TENDER DOCUMENTATION

ACCESS REVIEW - CONCERT HALL

This report is for the assessment of the Concert Hall portion of the Sydney Opera House Renewal Project to assess compliance with the provisions of the Disability Discrimination Act 1992, the Disability (Access to Premises – Buildings) Standard and the National Construction Code together with the relevant Australian Standards.

This report is based on the tender architectural documentation prepared by ARM Architects for the Concert Hall refurbishment works.

Project
BUILDING RENEWAL PROJECT - CONCERT HALL
Title
DETAIL AREA - ENTRY L1 - PLATFORM LIFT 37 - LEVEL 1 +30

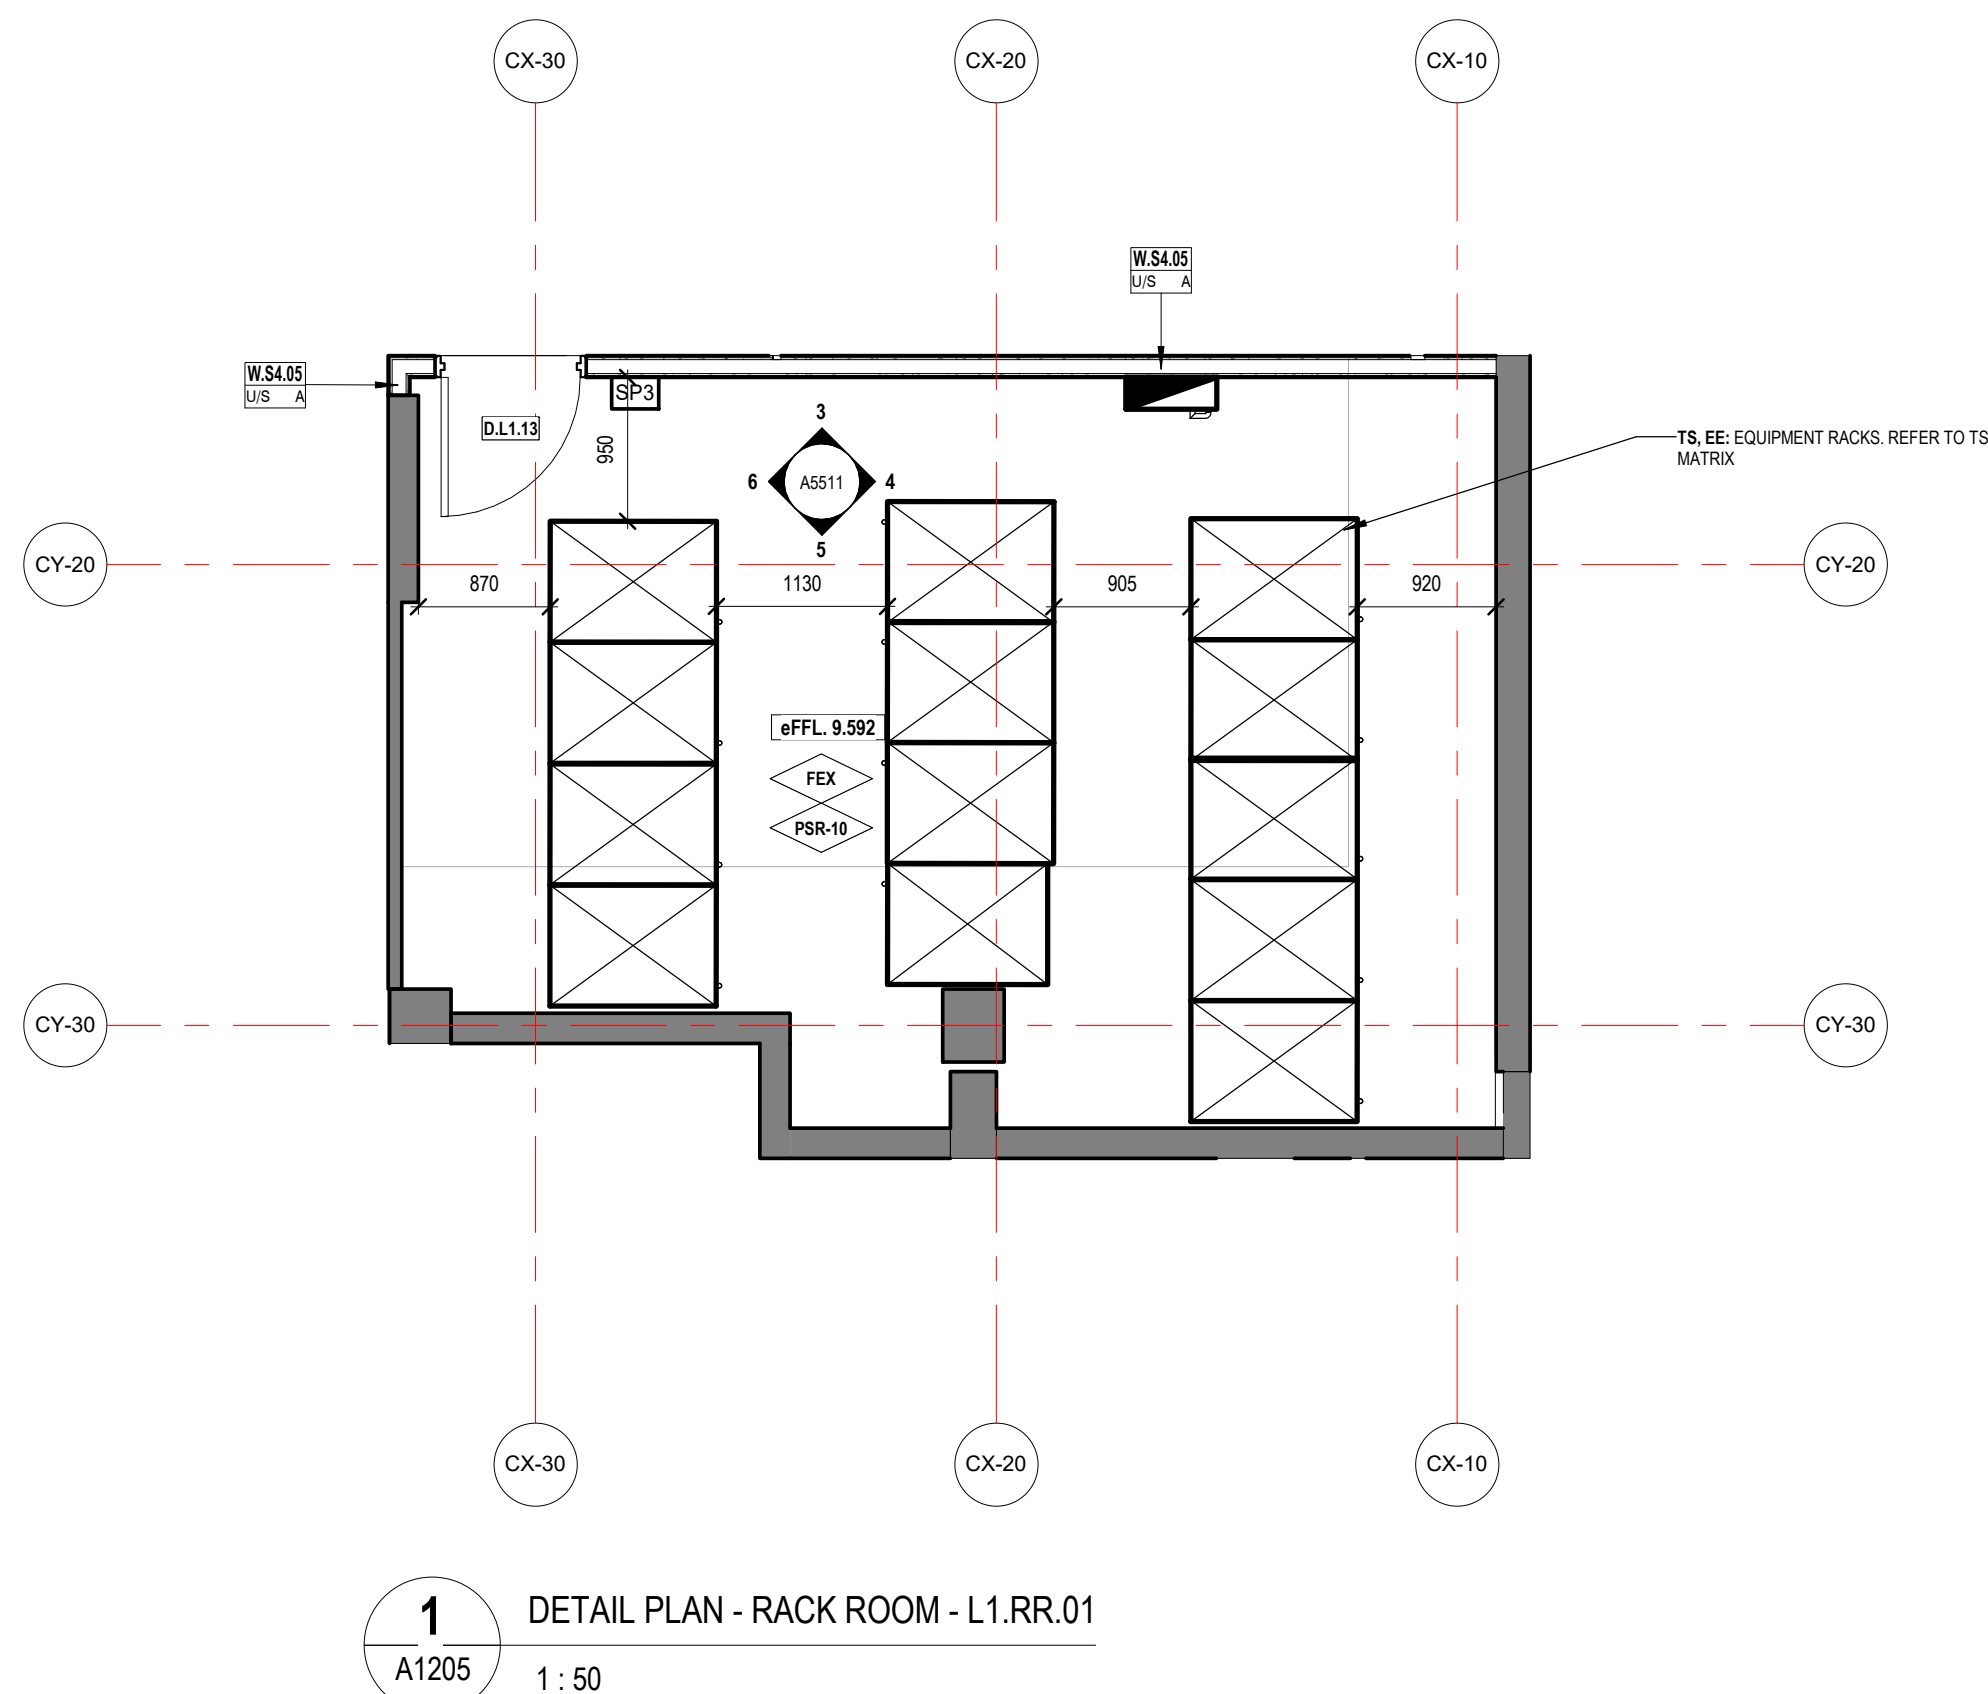
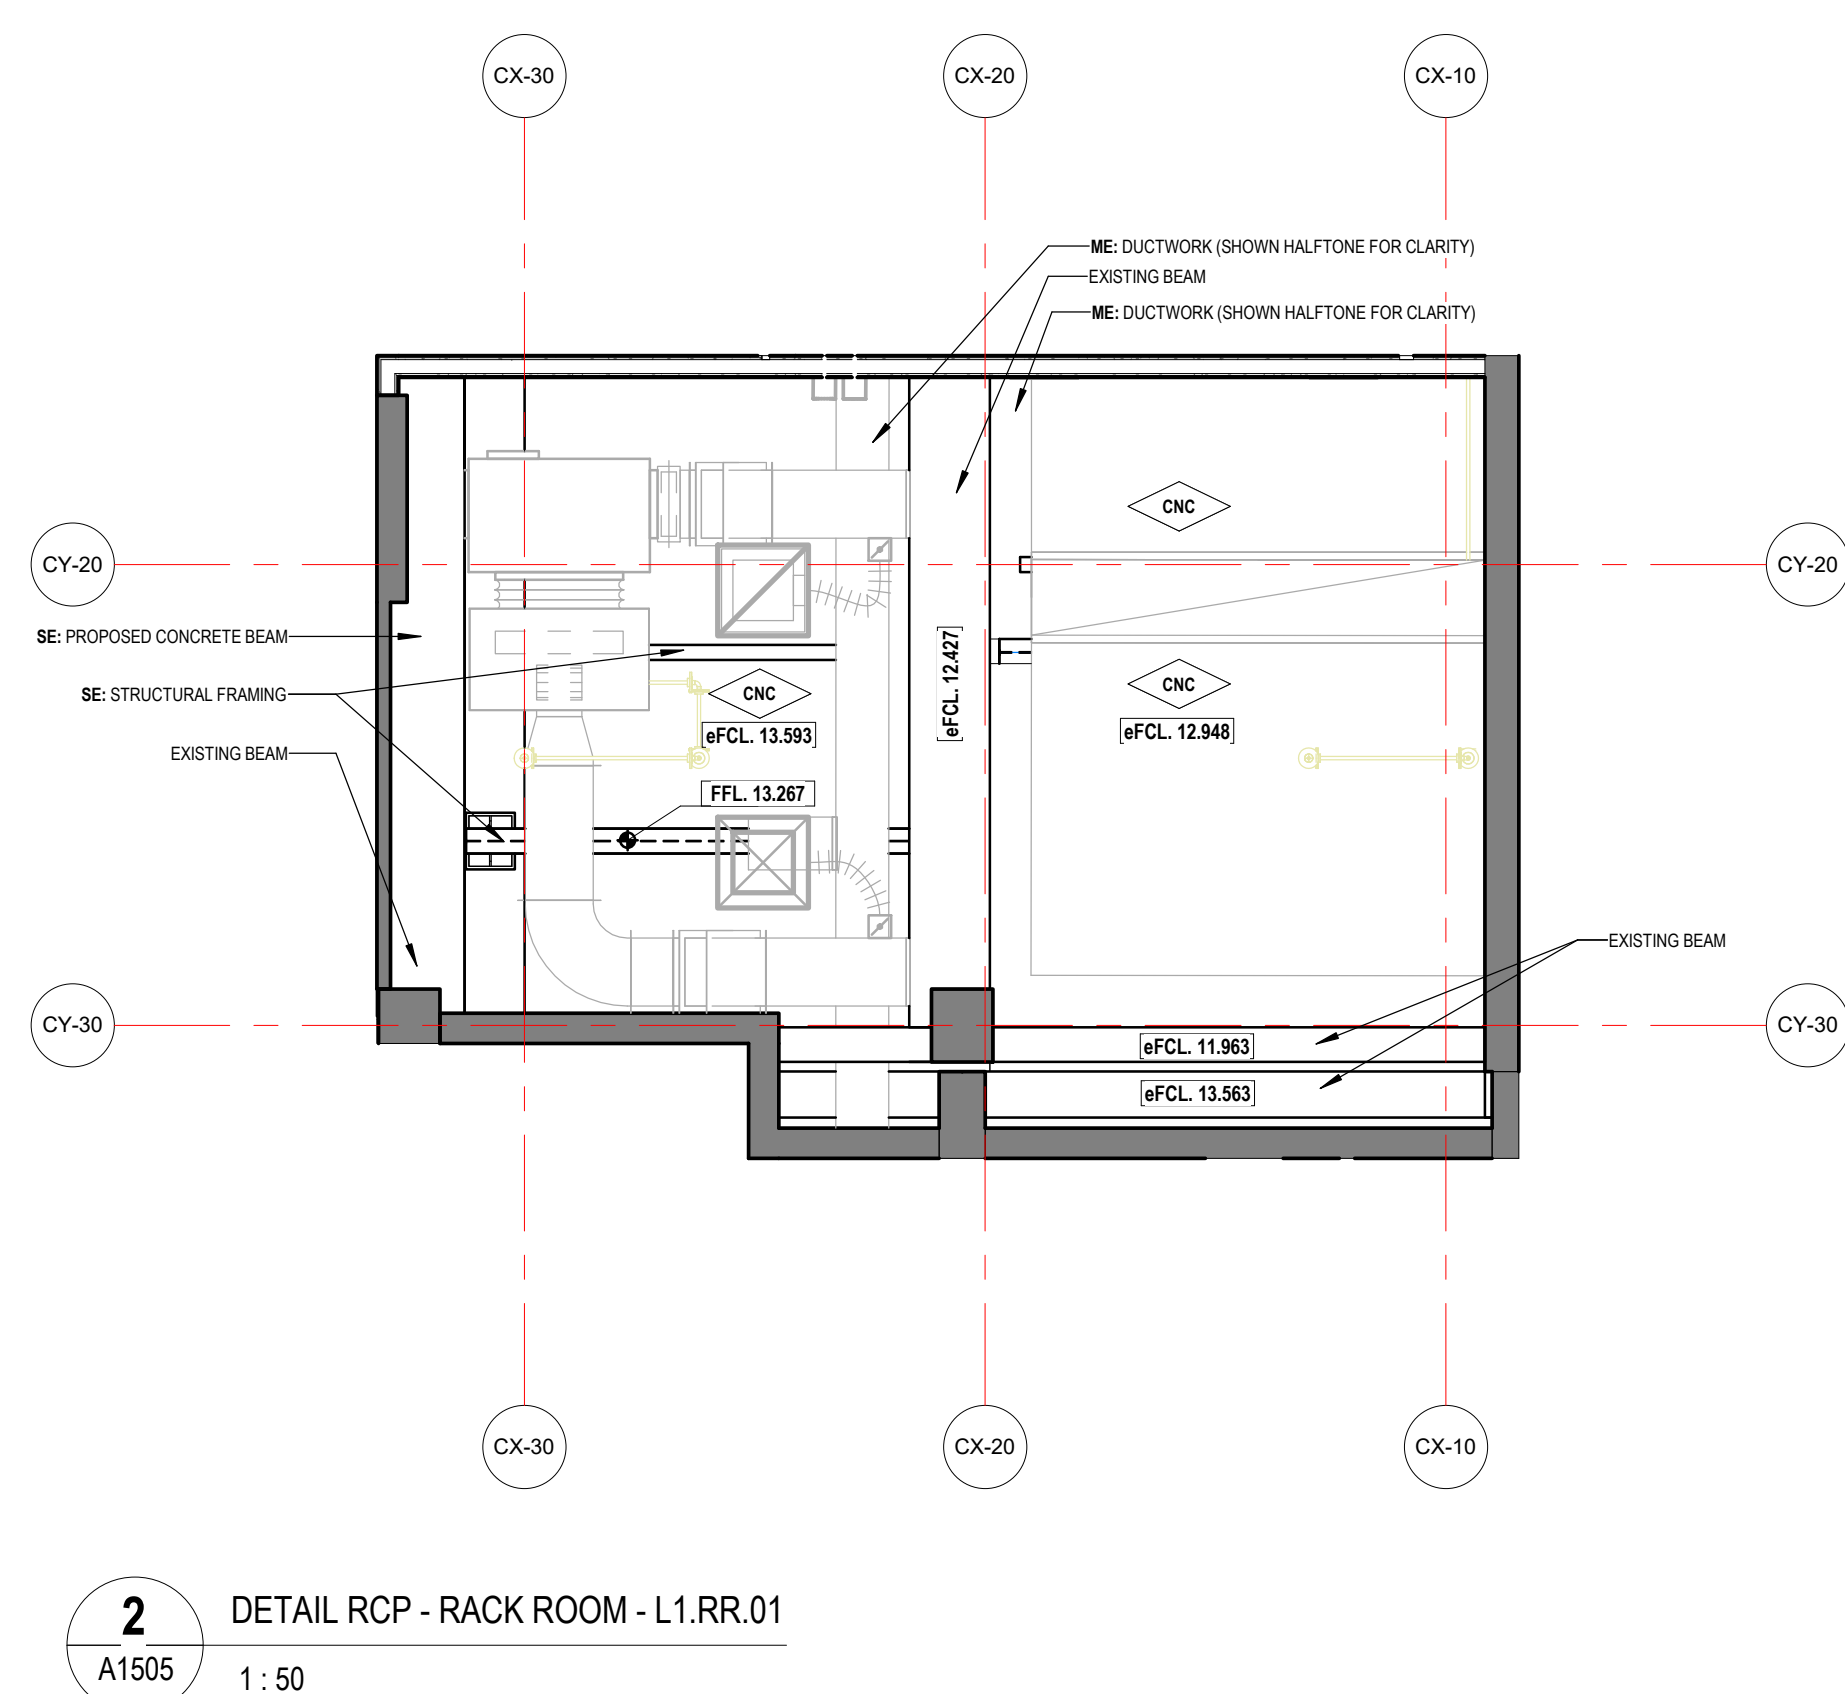
10.3 Ramps	Satisfied	The ramps accessing the Orchestra Assembly Room are addressed by way of a Performance Solution.
10.4 Curved walkways, ramps, and landings	Not Applicable
